Suffolk County Council (20050784)

Comments on submissions received at
Deadline 4

North Falls (EN010119)

9.44 Cumulative visualisations at the onshore substation, including the Norwich to Tilbury Pylons wirelines Part 2 of 2 (Rev 0) [REP4-030]

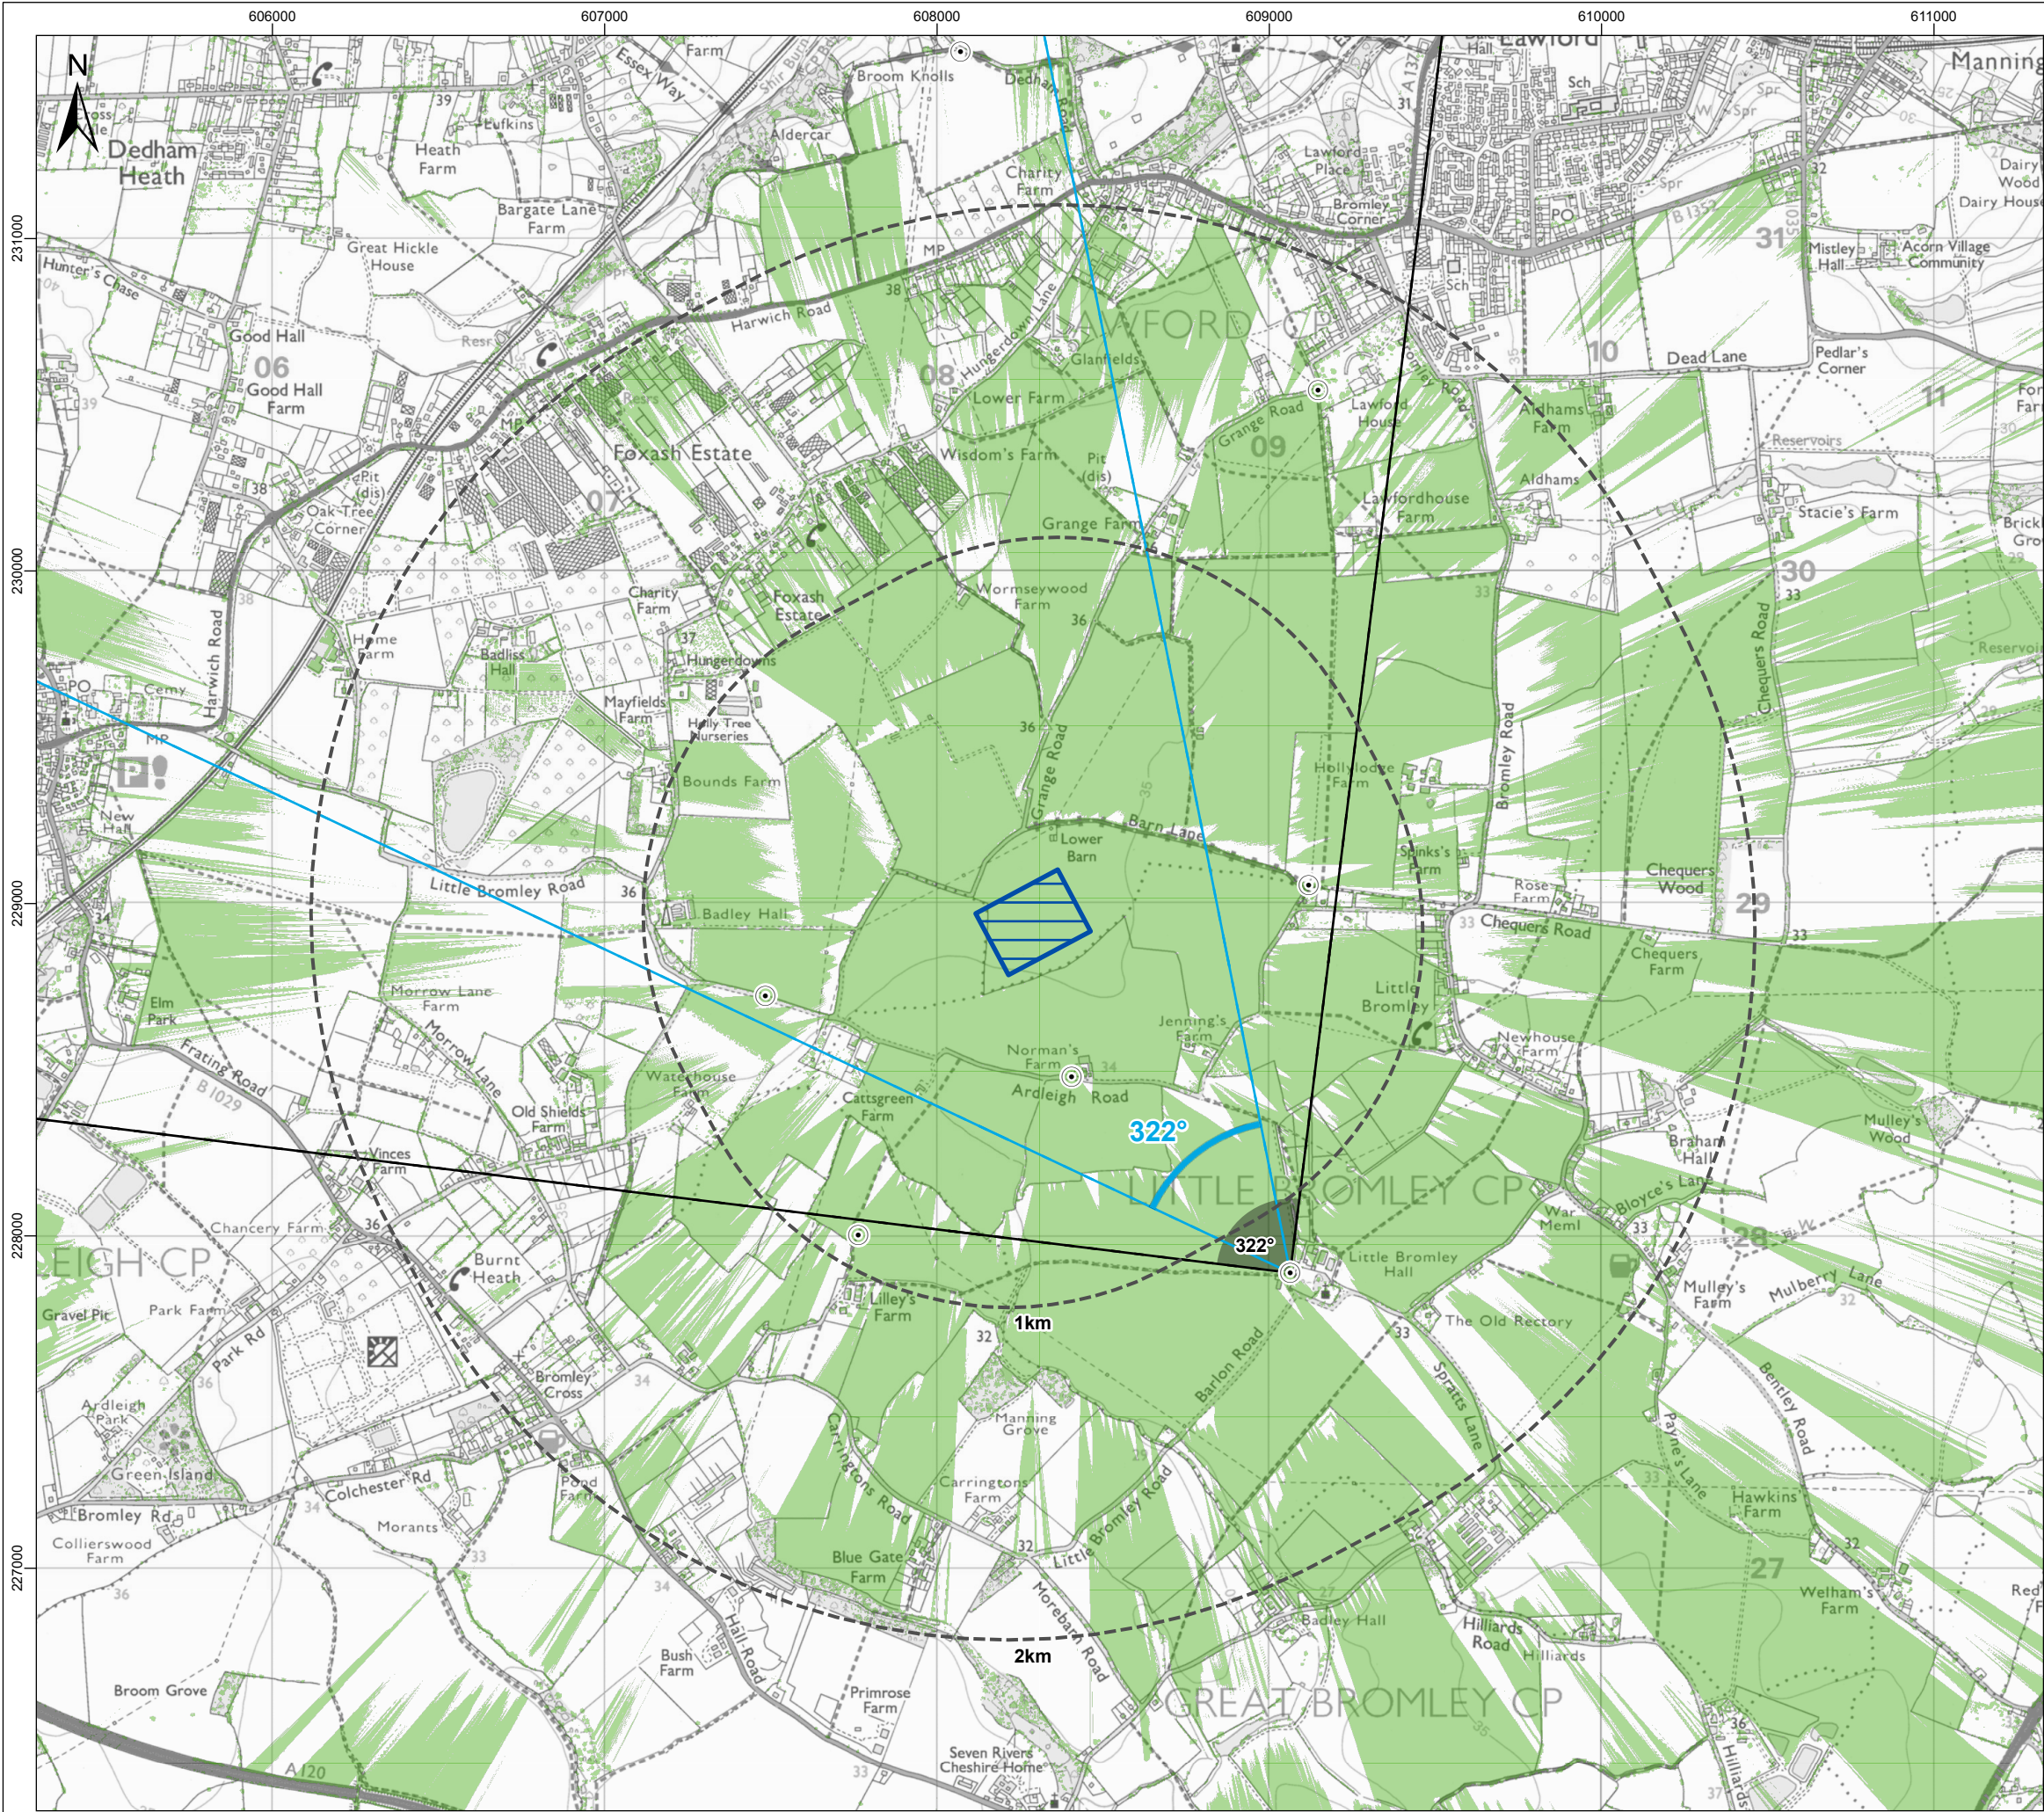
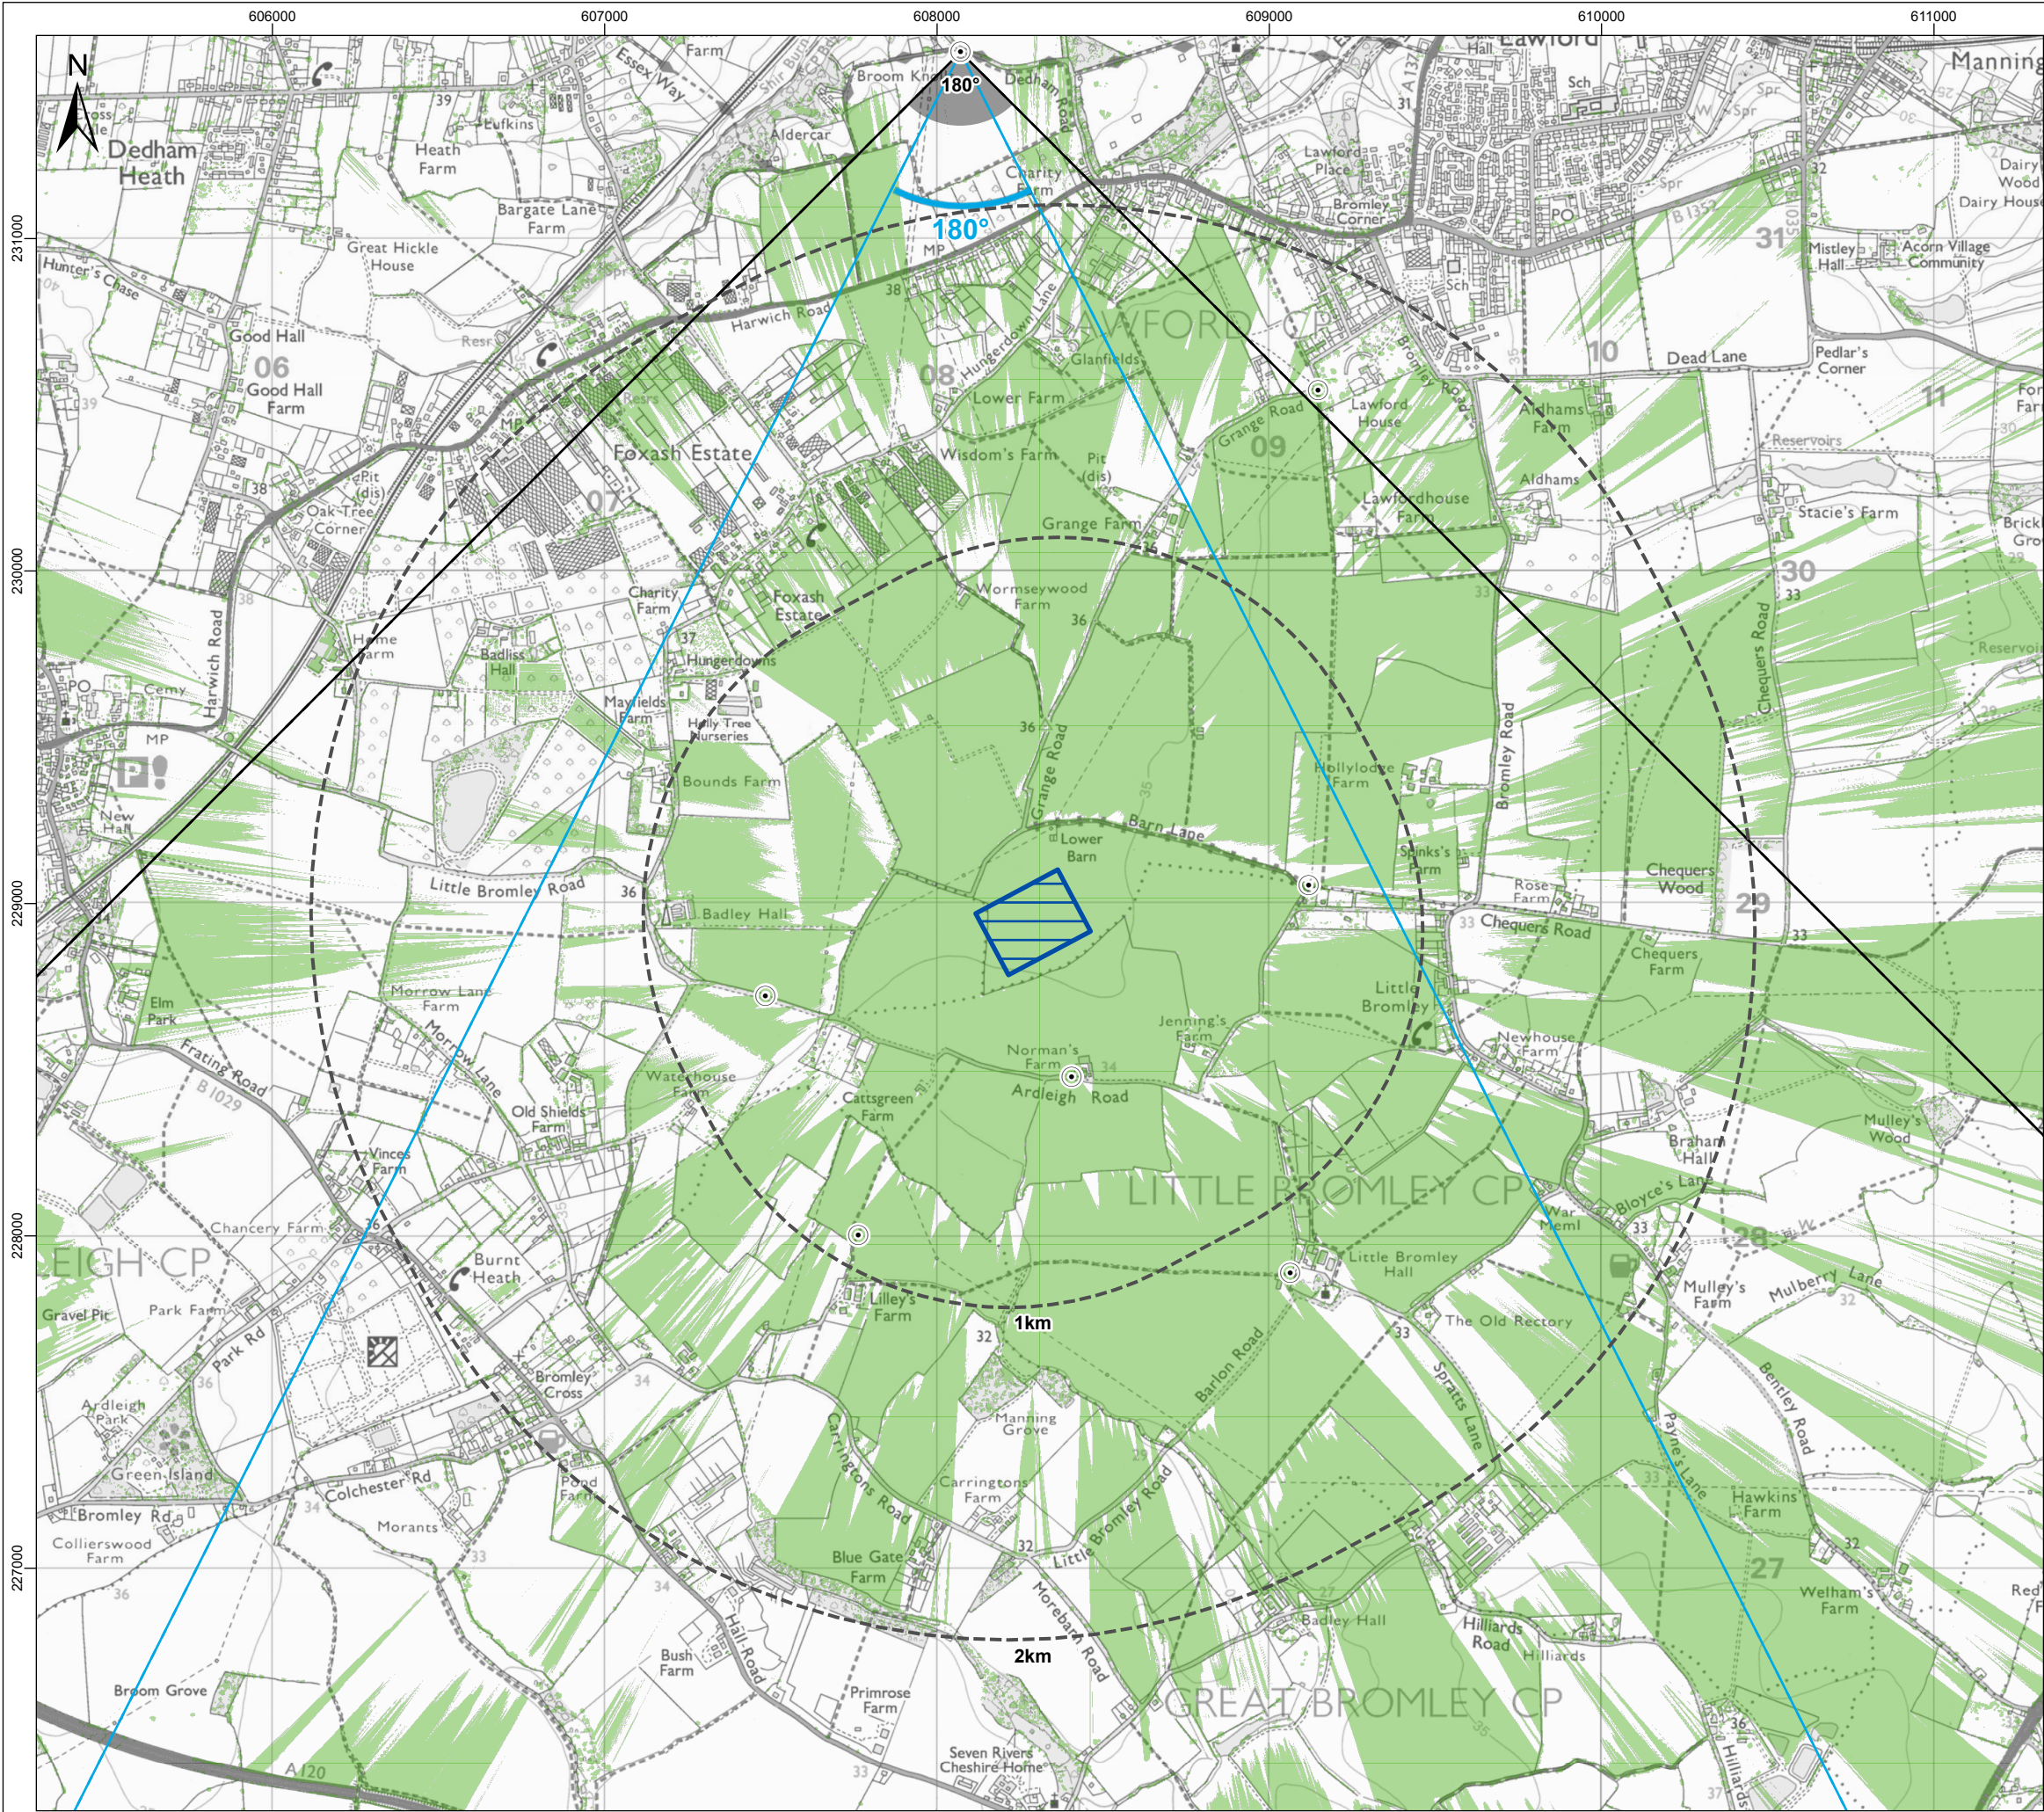
Table 1: SCC Table of Comments on 9.44 Cumulative visualisations at the onshore substation, including the Norwich to Tilbury Pylons wirelines Part 2 of 2 (Rev 0) [REP4-030]				
Ref.	Topic	Paragraph Number	SCC's Comments	References
1a	Cumulative Visual Impacts	Figures 30.2.6c & 30.2.7c	<p>SCC welcomes the additional wirelines showing the Norwich to Tilbury Pylons.</p> <p>Only two viewpoints relate to views from directions of the National Landscapes: VP6, Grange Road, for the SECHNL and VP8, Essex Way, Dedham Road for the DVNL. From both viewpoints the pylons would be visible, but in neither view would they introduce a completely new element to the view or be dominant in the view. It is noted that VP6 is not located within the DVNL and therefore does not relay a view from within the DVNL.</p> <p>With regards to VP8, the question remains as to why this location was chosen, where the ZTV suggests limited visibility, and not a location on the Essex Way further south-west where the ZTV suggests greater visibility. In ISH1 and the Applicant's corresponding written summary [REP4-026], the Applicant states that unassessed ZTV are outside of the 2km study area. However, the location referenced here by SCC is closer to the proposed substation than viewpoint 8, meaning that it is within the 2km study area. SCC considers that the inclusion of this viewpoint would benefit the examination in deciding whether the DVNL is affected by the proposed development.</p>	[REP4-026]
